**Re: Section 75W Modification Application (MP08_0241 MOD 2)
86-96 and 100 Mount Street, North Sydney**

I refer to the above application and the Department's letter dated 21 January 2014 seeking Council's comments and advice on the modifications and conditions of approval.

Ground Floor Plan

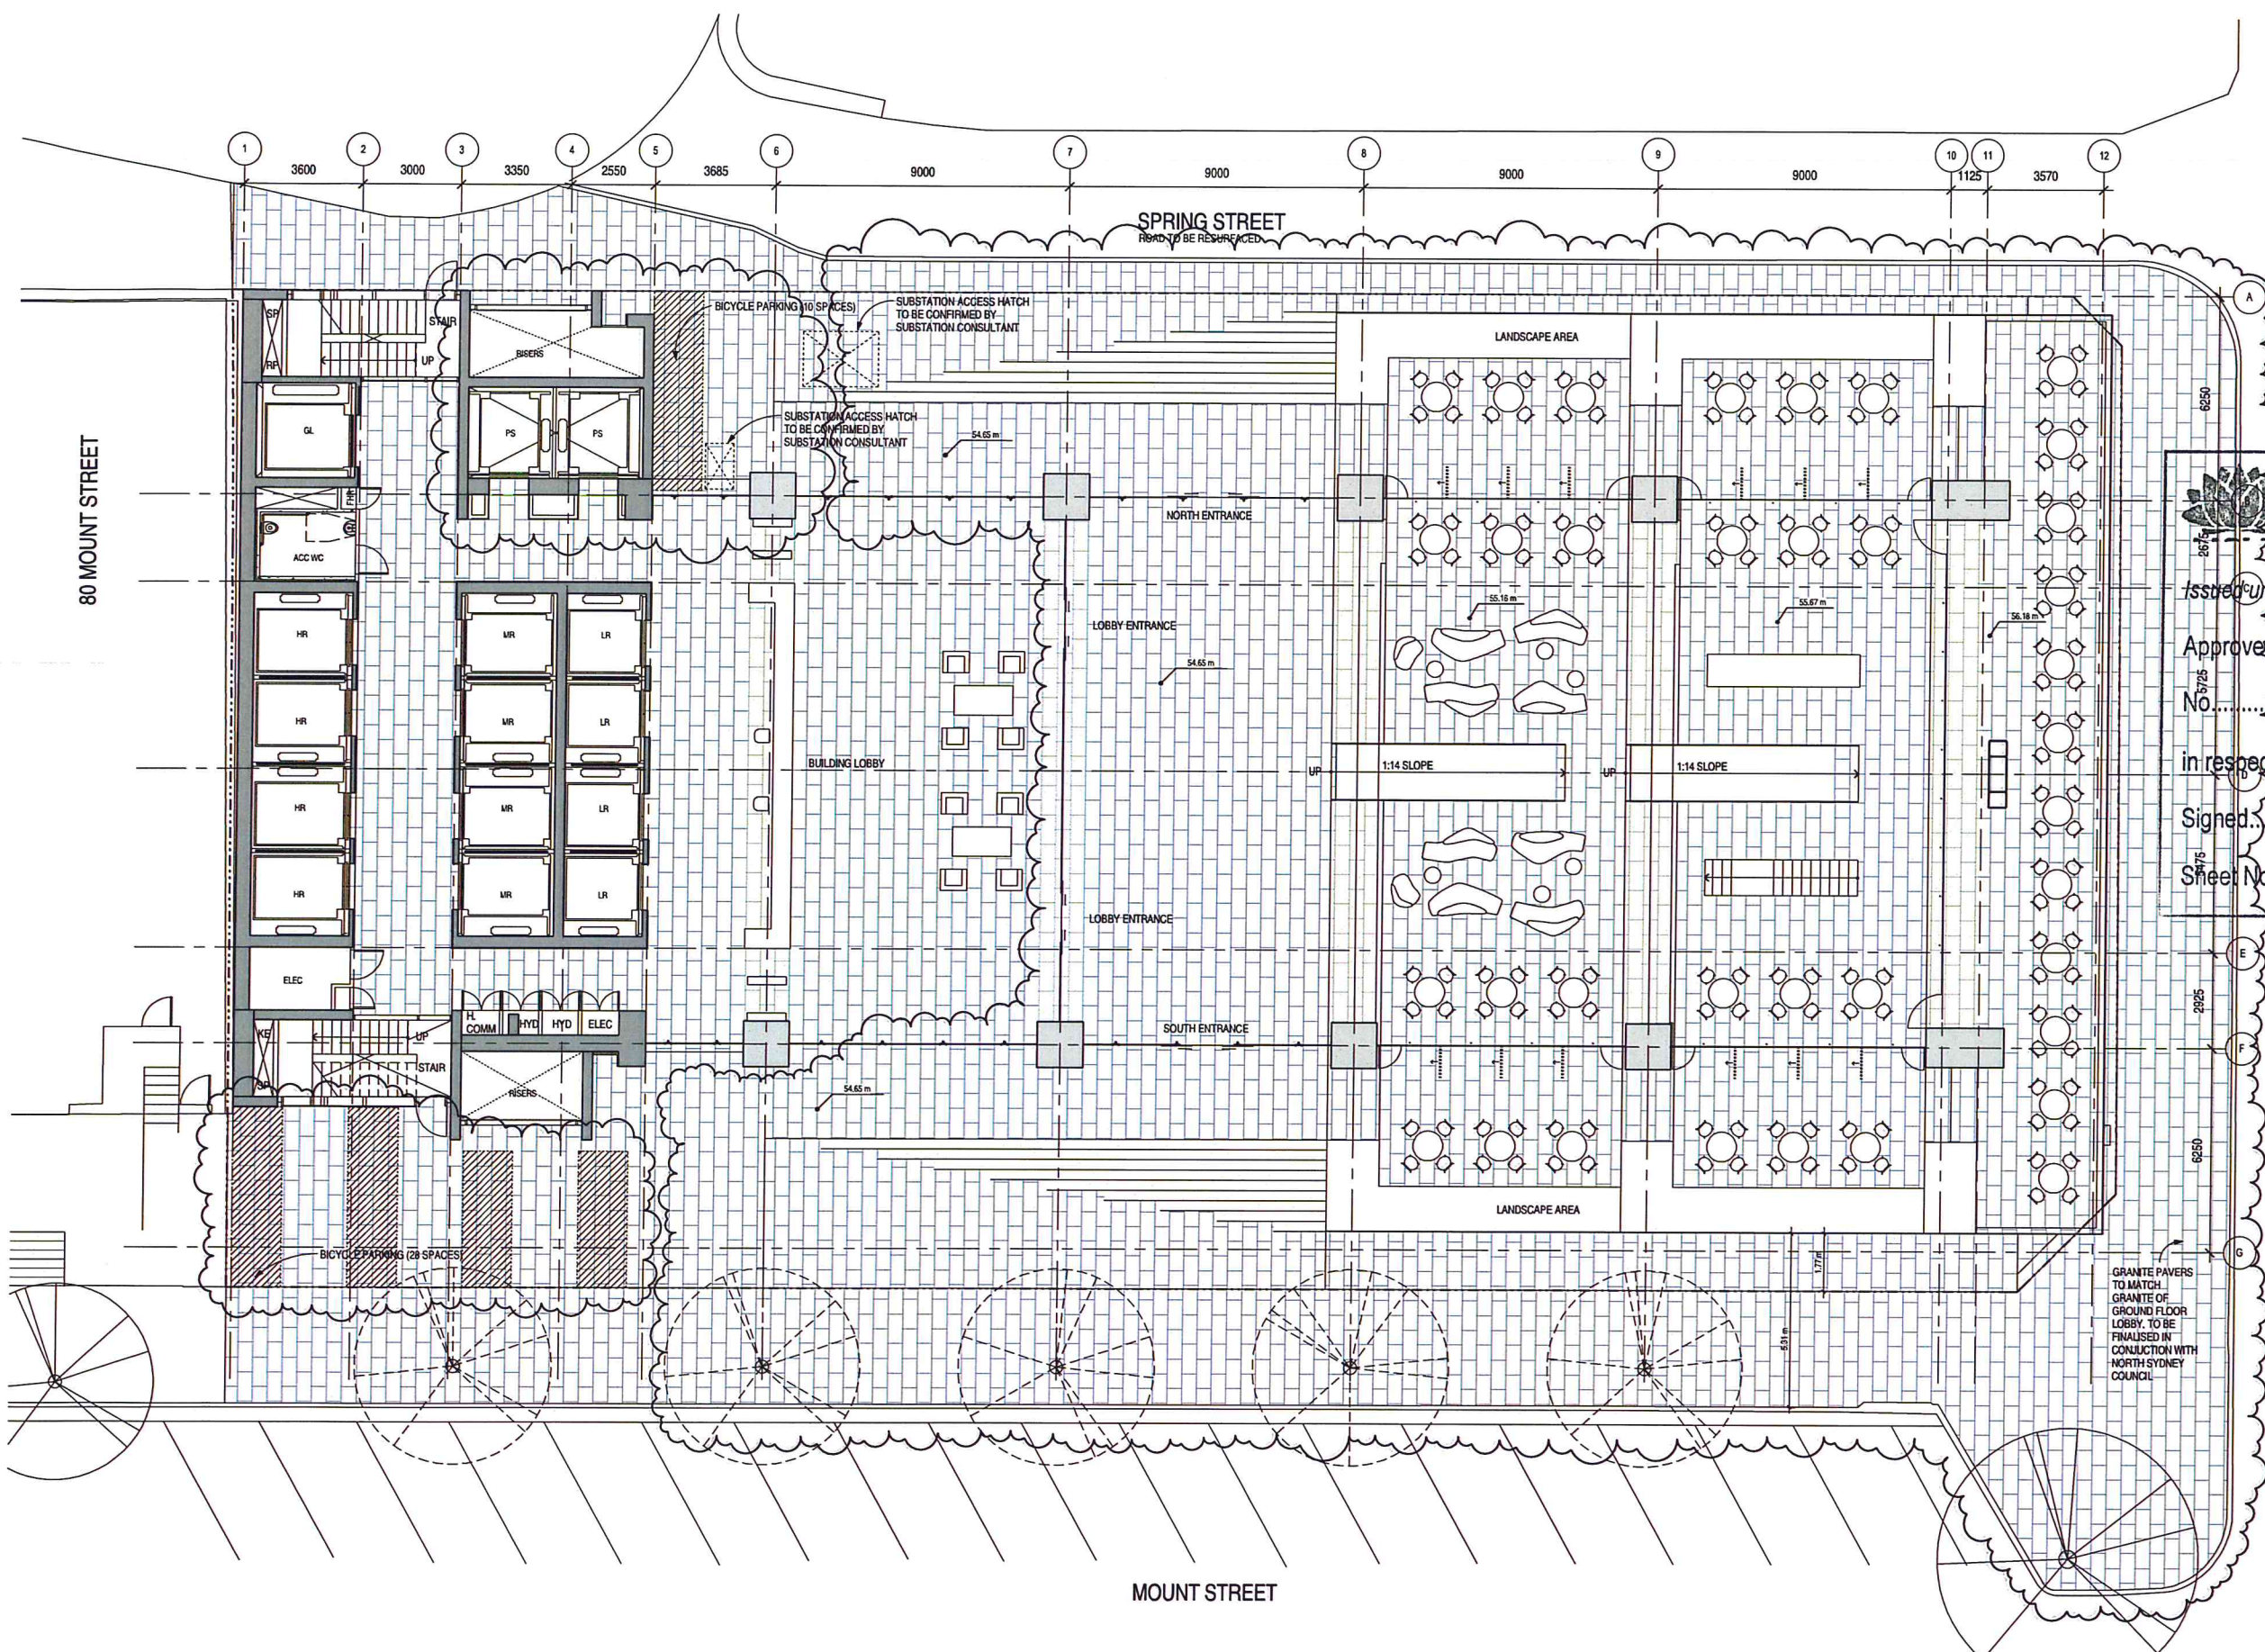
- The bike parking on the ground floor plan, at Mount Street and Spring Street, is consistent with designs indicated in the *North Sydney Public Domain Style Manual* and installed in accordance with AS2890.3 and other relevant codes of practice. The bike parking design must be submitted to Council for approval by Council's Manager Traffic Planning.
- The bicycle parking and storage facilities in the basement comply with the Australian Standard AS2890.3.

- That the design for the public domain and publicly accessible areas at ground level be in accordance with the design and materials palette outlined in the *North Sydney Public Domain Style Manual*. The detailed designs for these areas must be submitted to Council for approval by Council's Director Engineering and Property Services.

drawing  
Plan - B1 Level

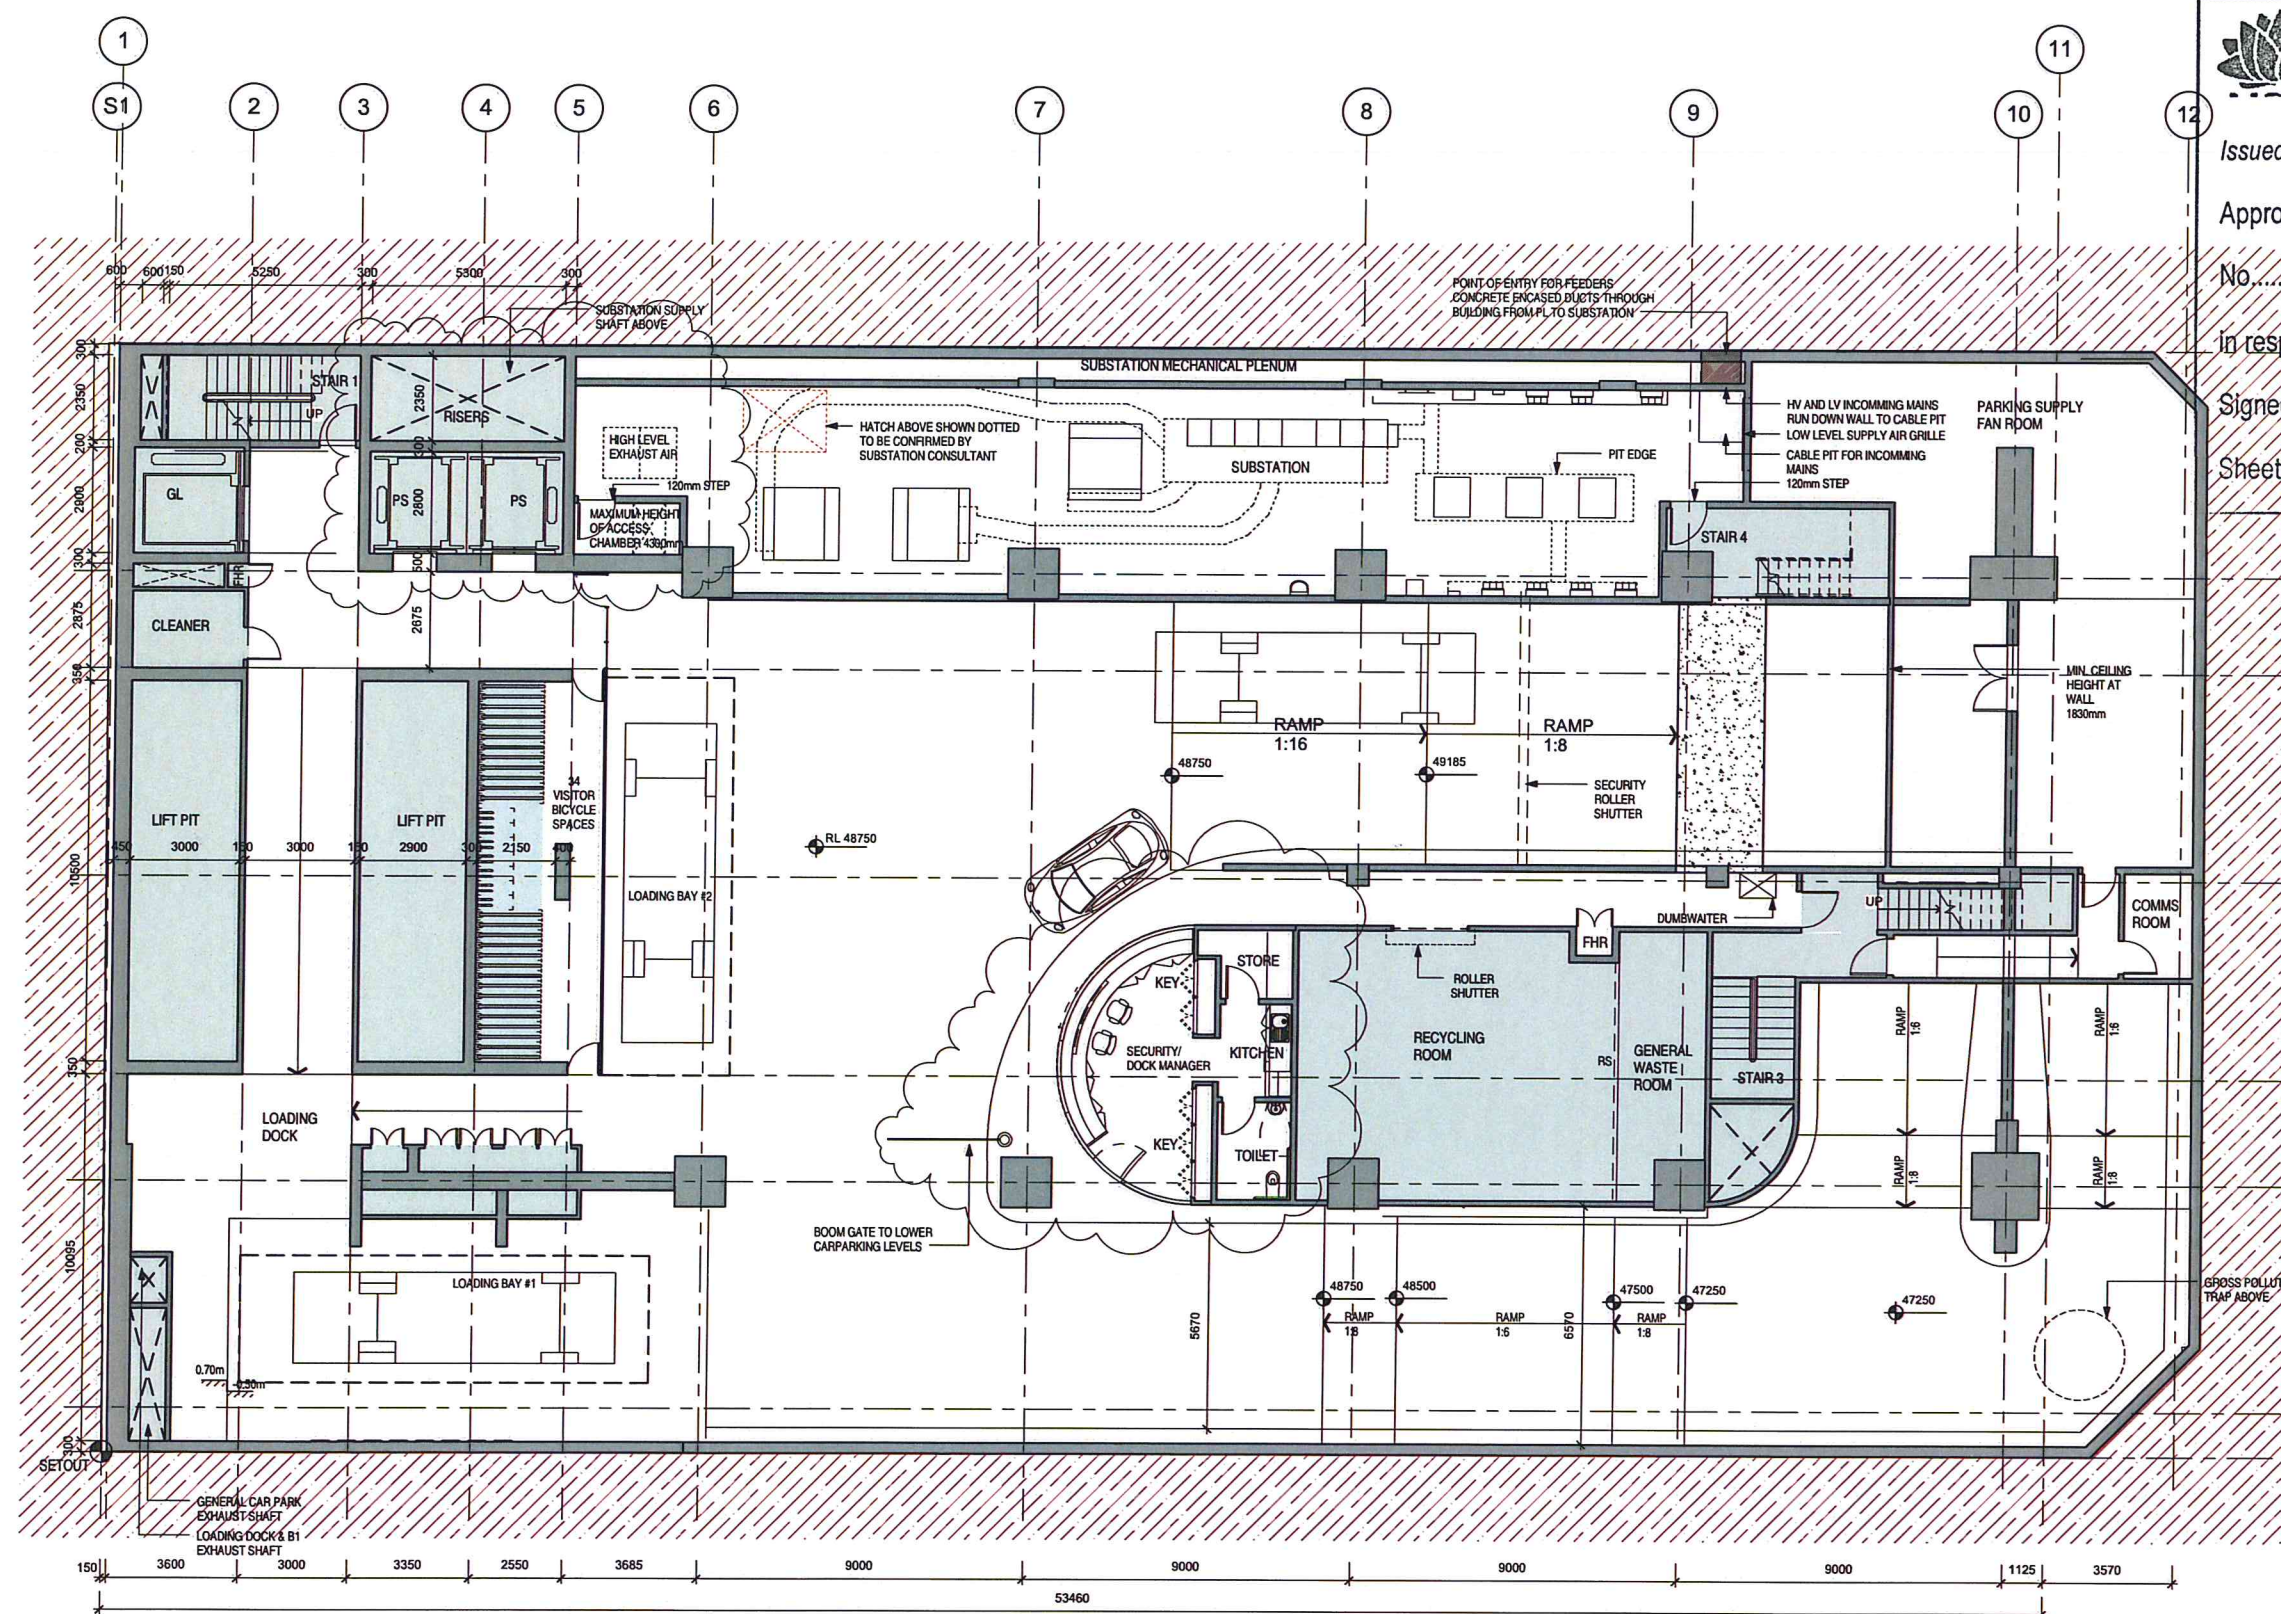
With regards to the new proposed loading dock on B1, there are serious concerns with its compliance with AS2890.2. To address these concerns the following condition should be imposed:

- That the design of the loading docks in B1, including dock length, width, height and aisle widths be compliant with AS2890.2.
- That further plans showing an AutoTURN or AutoTRACK simulation of the largest possible vehicles likely to access the loading dock (Medium Rigid Truck as defined in AS2890.2) entering and leaving each loading dock in a forwards direction.
